**Subject:** B5b Urban Commercial Business Zones Design Review – 185 Fore St.

**Written by:** Caitlin Cameron, Urban Designer

**Date of Review:** Wednesday, February 25, 2015

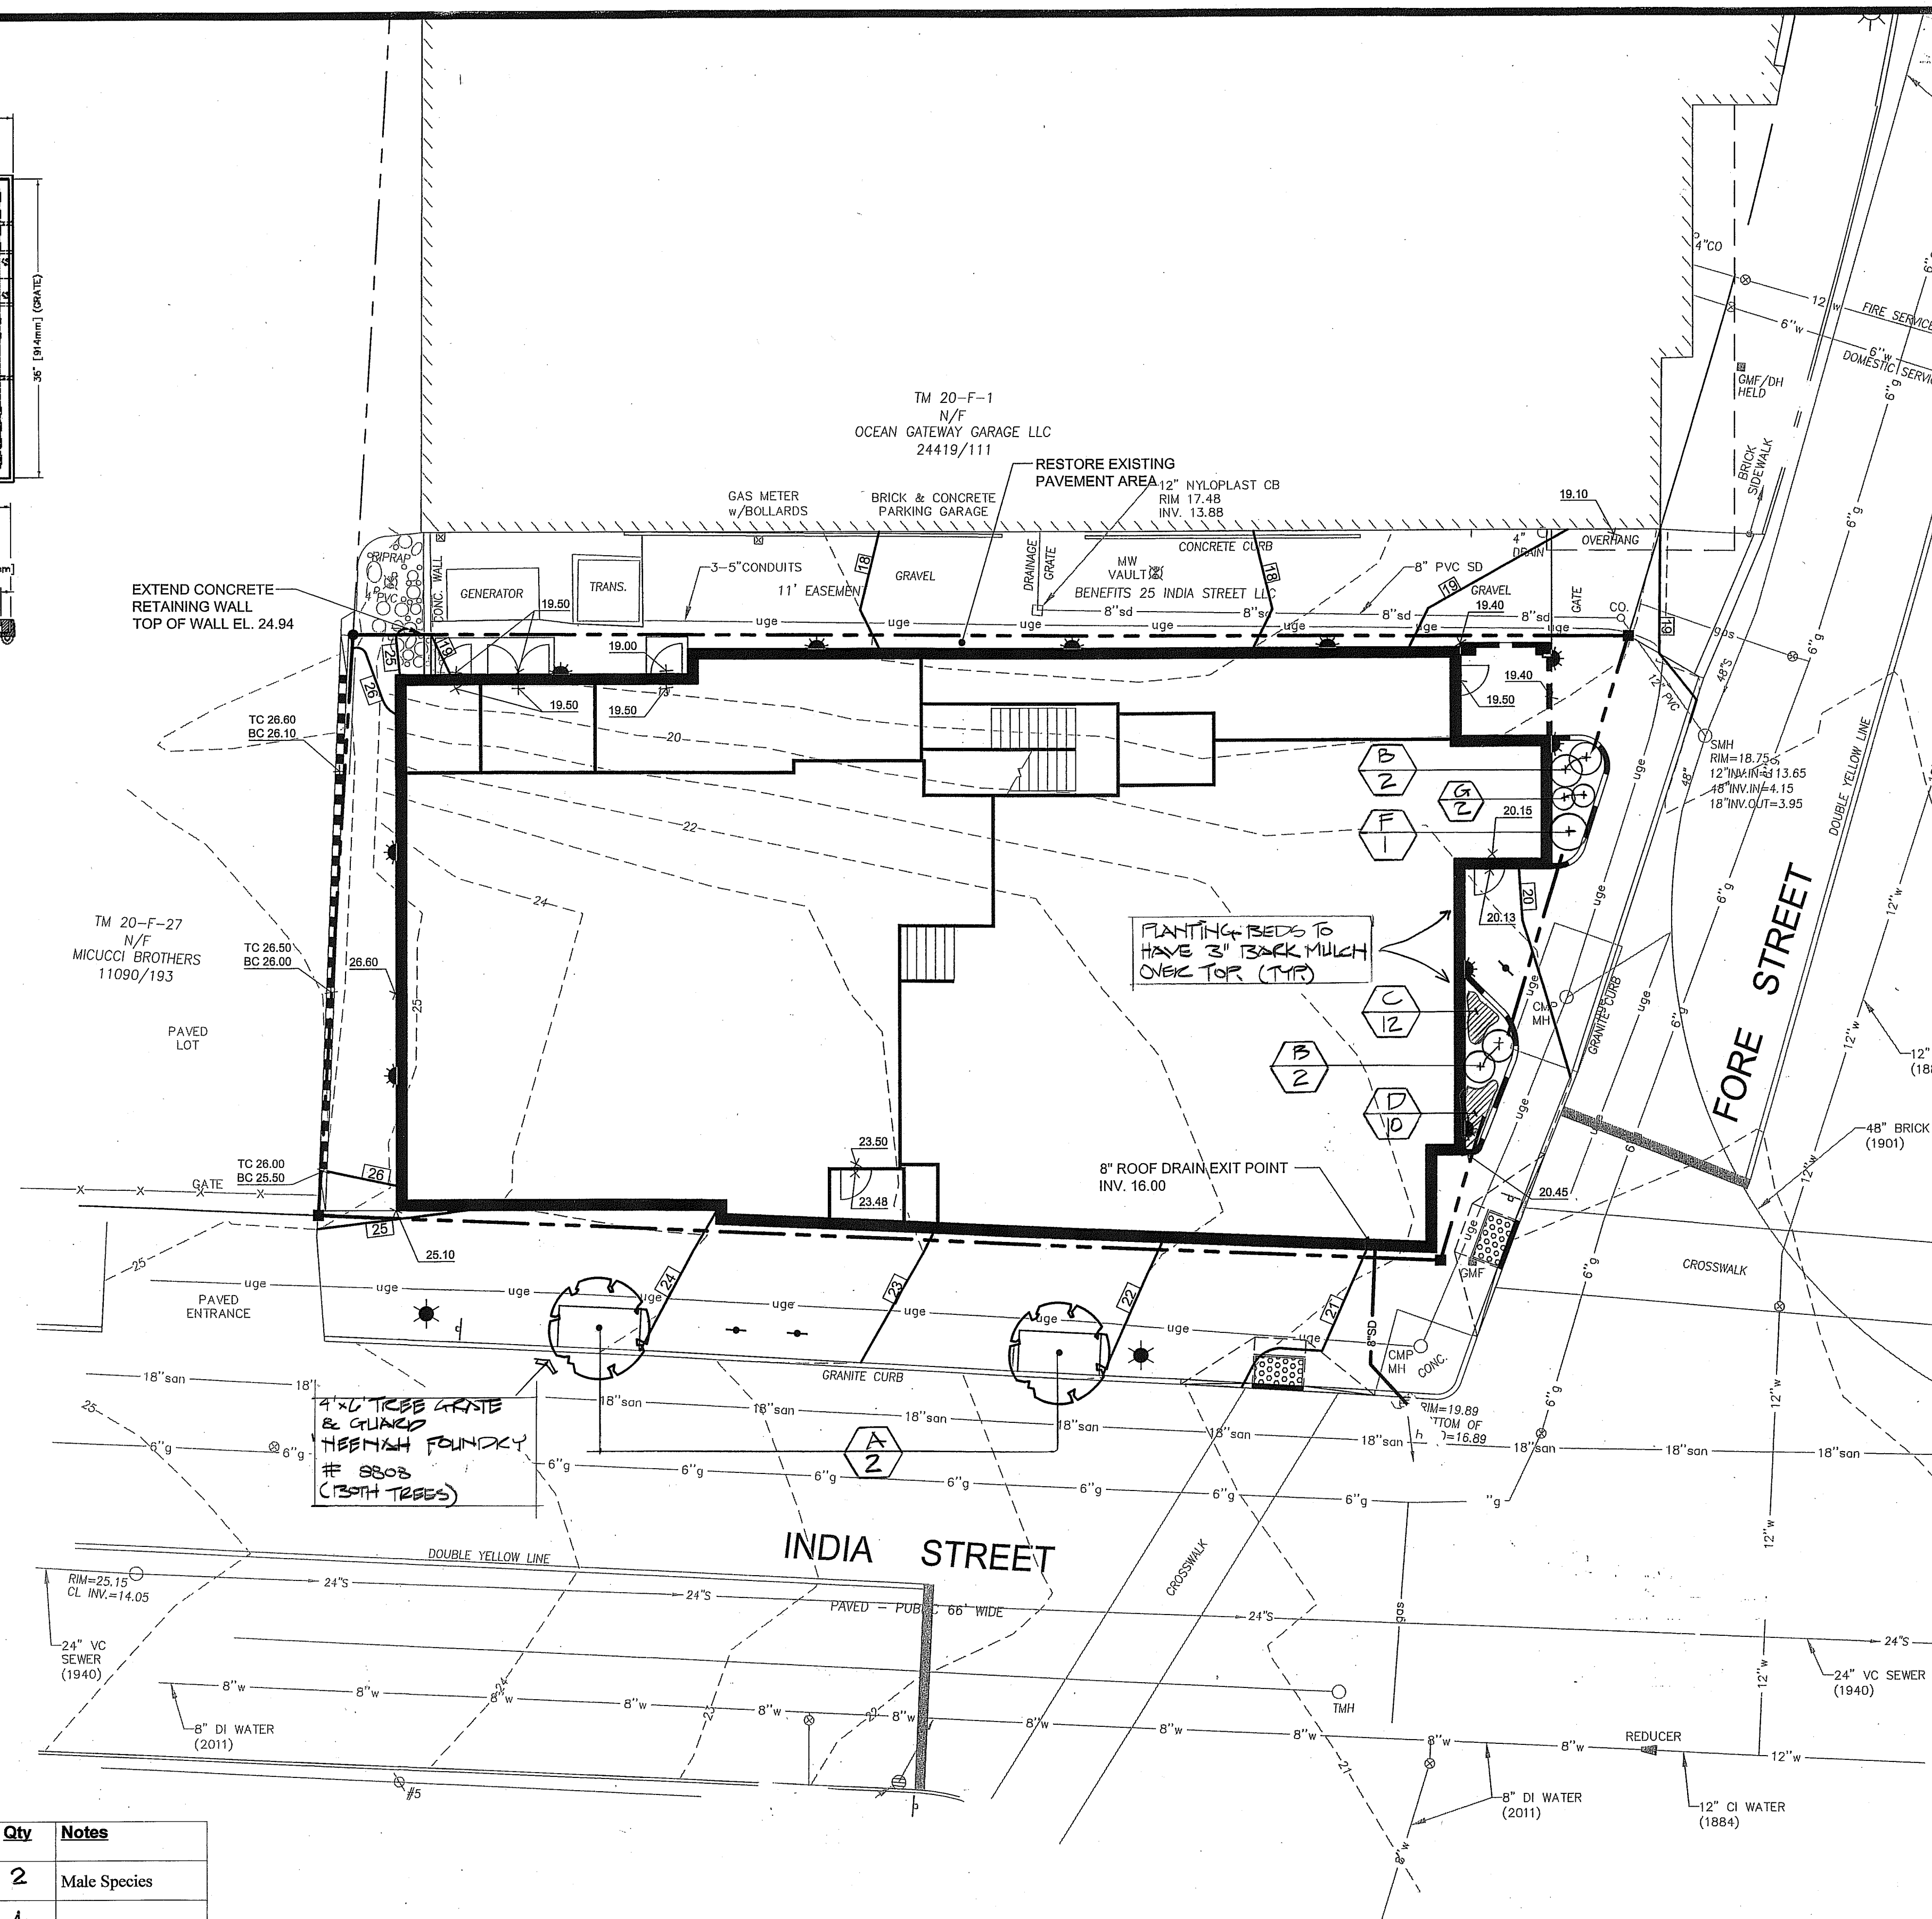
*Standard 1b. Relationship to Street* – Building is set close to property line on all frontages including corner. **Staff requests that landscaping shown adjacent to retail façade on India Street be removed, especially on India Street. Although staff recognizes the intent was to ameliorate the inability to provide street trees in these locations, staff is not in support of placing landscaping between sidewalk and active ground floor facades. A wider sidewalk and easy access to the ground floor uses are preferred. City Arborist is amenable to removing the proposed landscaping. Landscaping on Fore Street might need to be maintained to meet Open Space requirement of Multiple-Family Design Standards for dwelling units without balcony.**

*Standard 1(a)2. Relationship to Street* – Met – Staff appreciates the infill nature of this project and its location and orientation contributes to the overall street wall and character of India Street. Ground floor has been adjusted to be closer to property line/sidewalk. **As stated above, placement of landscaping between sidewalk and building on India Street is not desired and does not reflect typical condition in the neighborhood.**
